September 28, 2022

Reference: New Mexico Proton Advanced Cancer Therapy (NMPACT)
Response to Development Review Board Planning – Case Comments
Project: PR-2022-007588
Application: SI-2022-01658

Title
DRB SITE PLAN

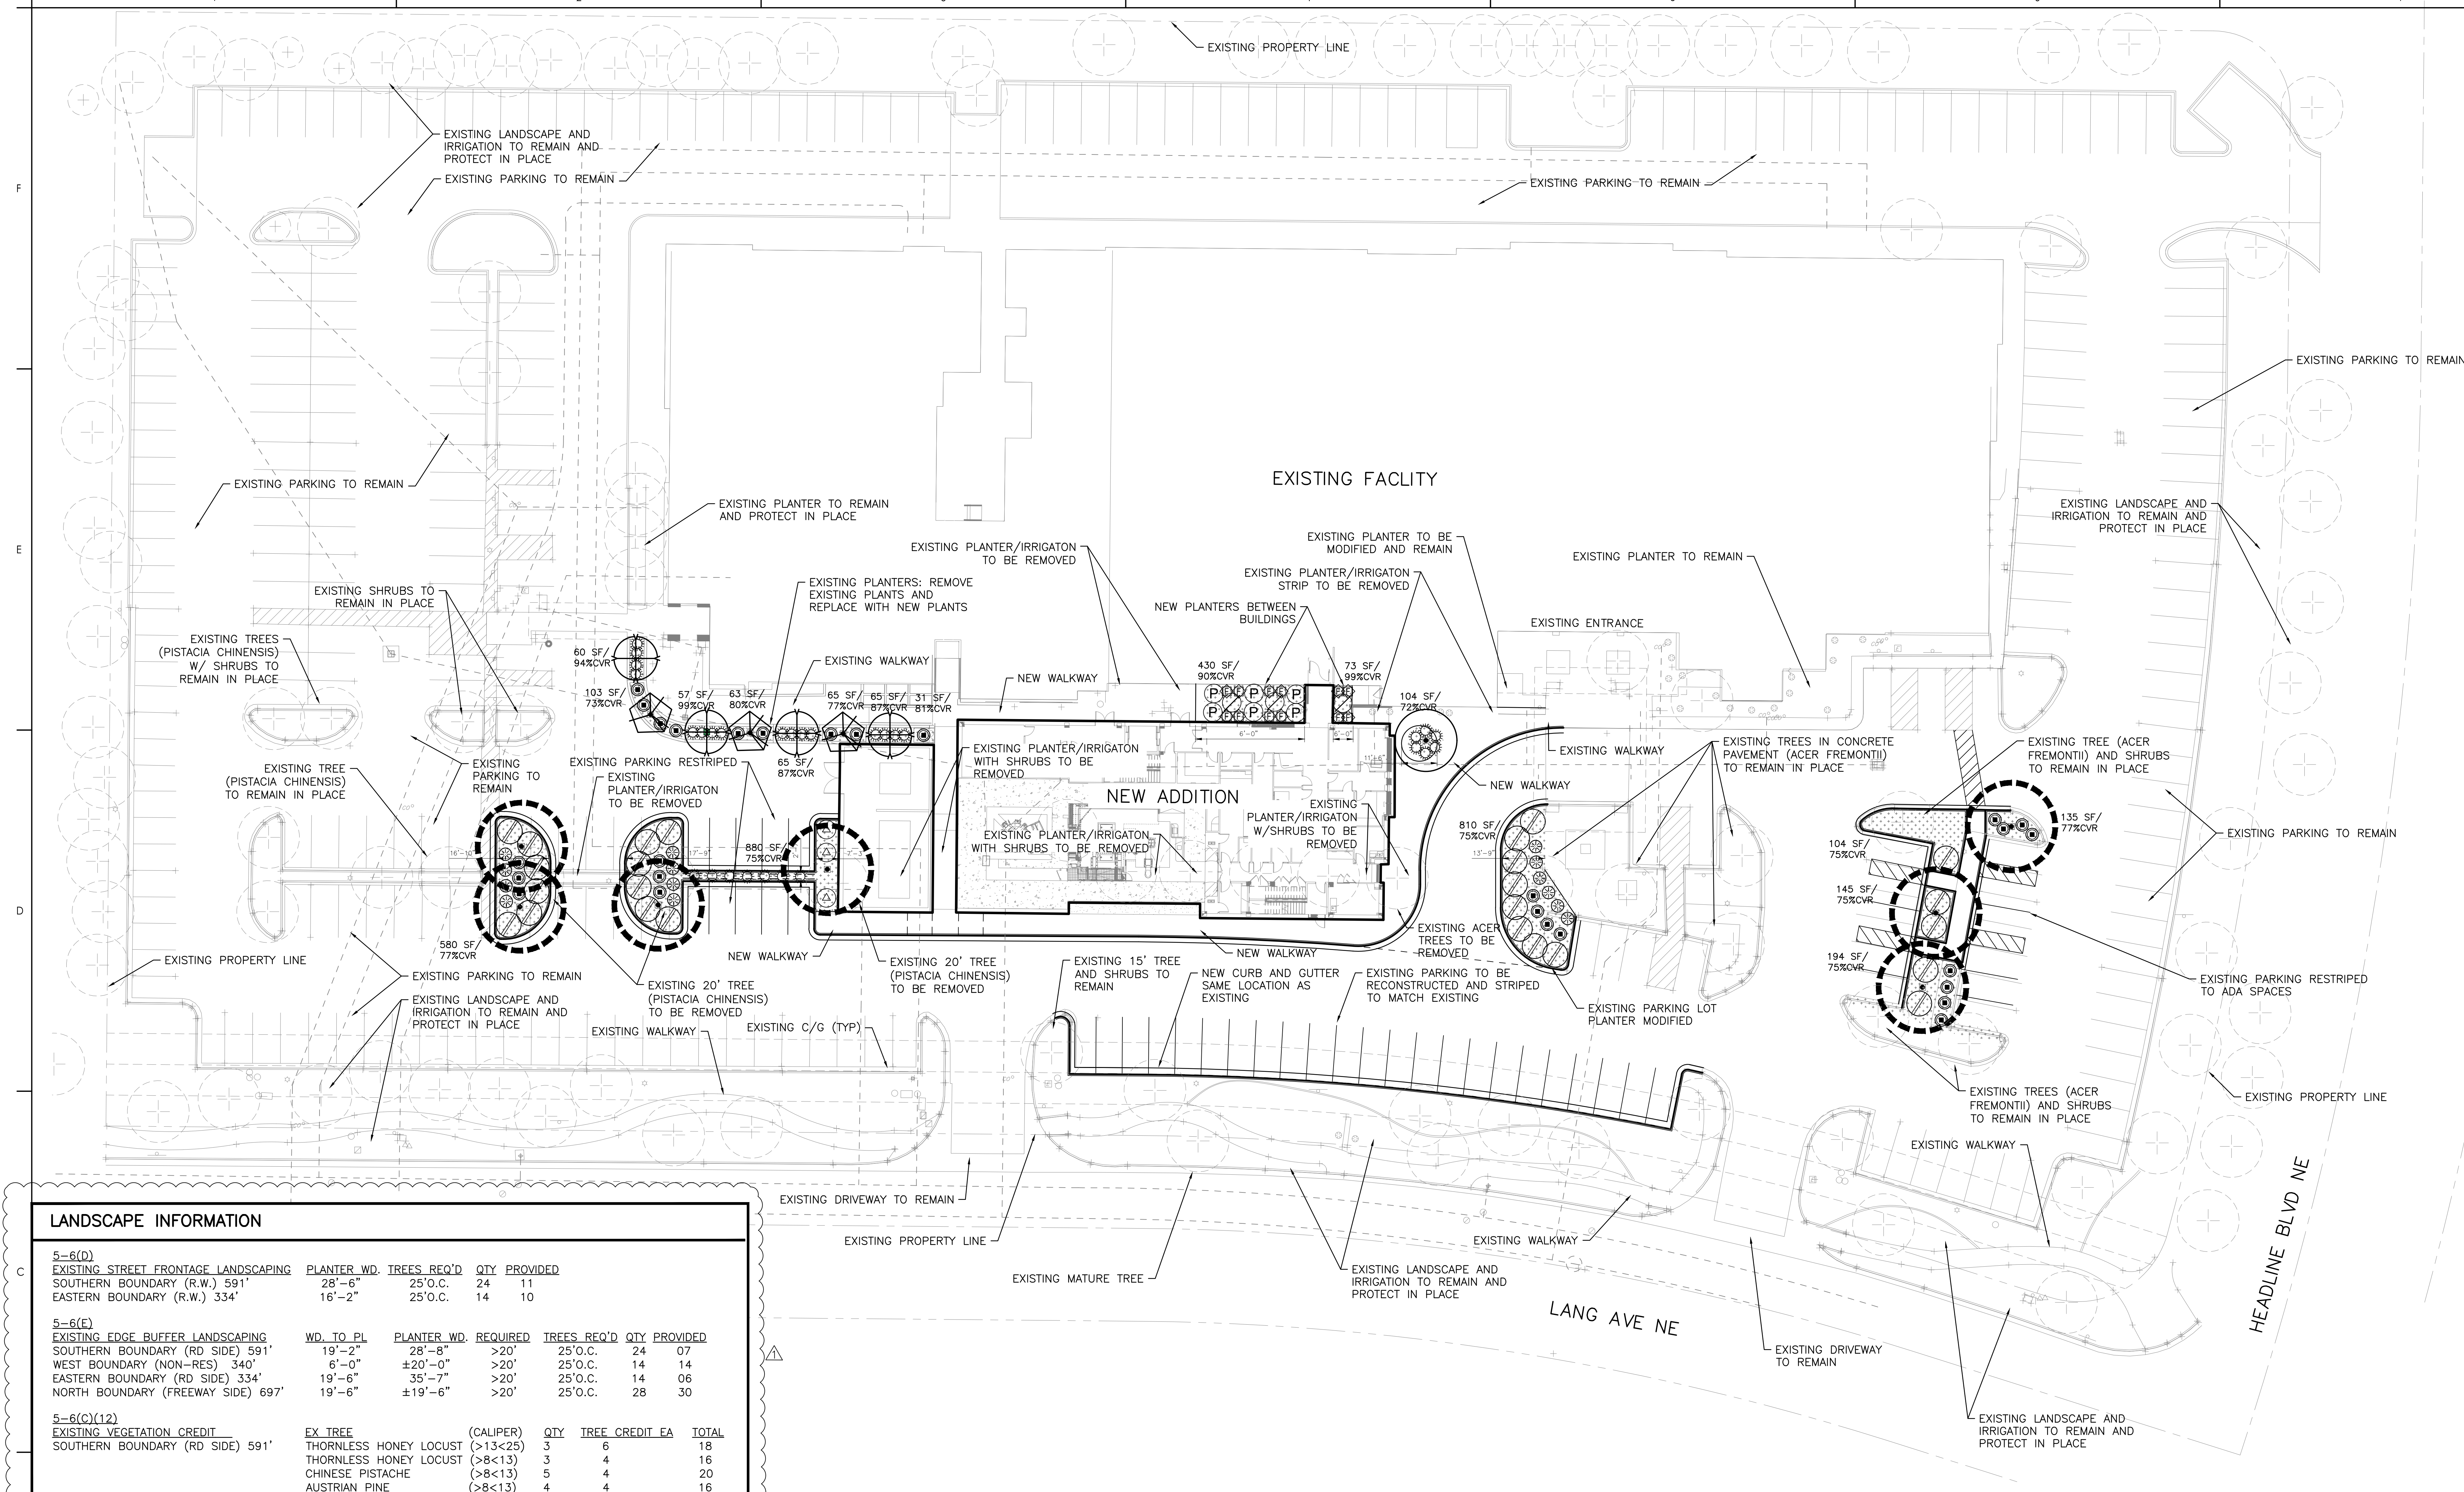
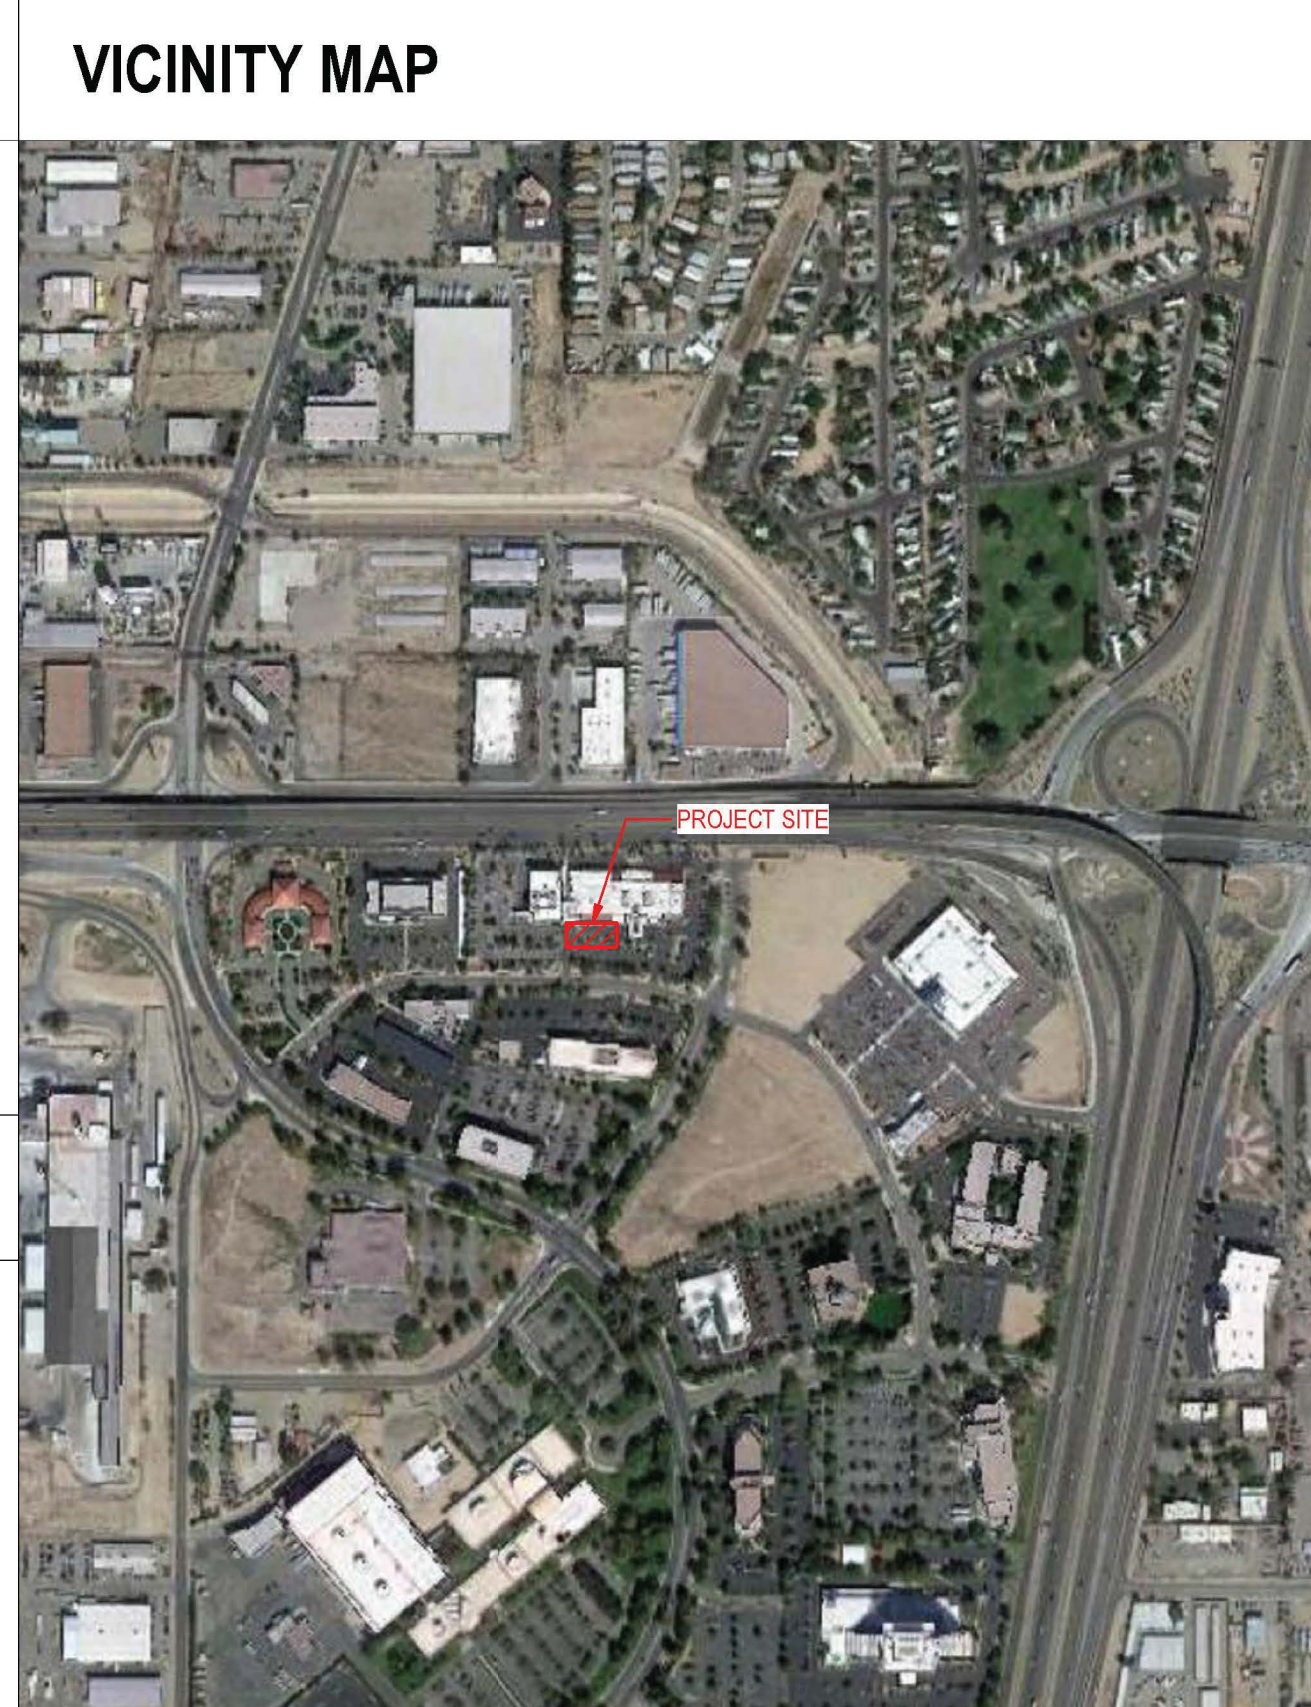
- b. On the Site Plans or site plan notes, please include detailed and relevant development information to help clarify new expansion and modifications. For example, setback & height measurements, buffer measurements, parking & landscaping calculations, new uses and/or changes in use.

7. The Parking Tabulation section of the Site Plan notes that 100 parking spaces will be provided off-site. If any off-site parking spaces will be utilized and will count toward the total of number of required parking spaces, a recorded Shared Parking Agreement will be required for those parking spaces and must be submitted prior to the approval of this Major Site Plan Amendment – DRB.

8. The number of bicycle parking spaces which are required are depicted in the Parking Tabulation section, but the number of bicycle spaces/racks which are being provided is not depicted. That information needs to be added to the Site Plan.

- i. *Stantec Response: We will revise and resubmit Sheet A1-100, Architectural Site Plan.*
2. The site is located within the Journal Center Master Plan. A letter of approval was received from the Journal Center Architectural Review Committee approving the proposed development. Staff needs more information on the façade to determine compliance.

- a. *Stantec Response: The Owner has a signed Parking Lease for sufficient spaces to cover the off-site parking requirement; see attached lease. The Owner will record a Shared Parking Agreement.*

- a. *Stantec Response: Sheet C-101, Site Plan will be updated with the required information and resubmitted.*
9. Detail as to how the required number of motorcycle spaces (6 spaces) was calculated needs to be provided in the Parking Tabulation section.
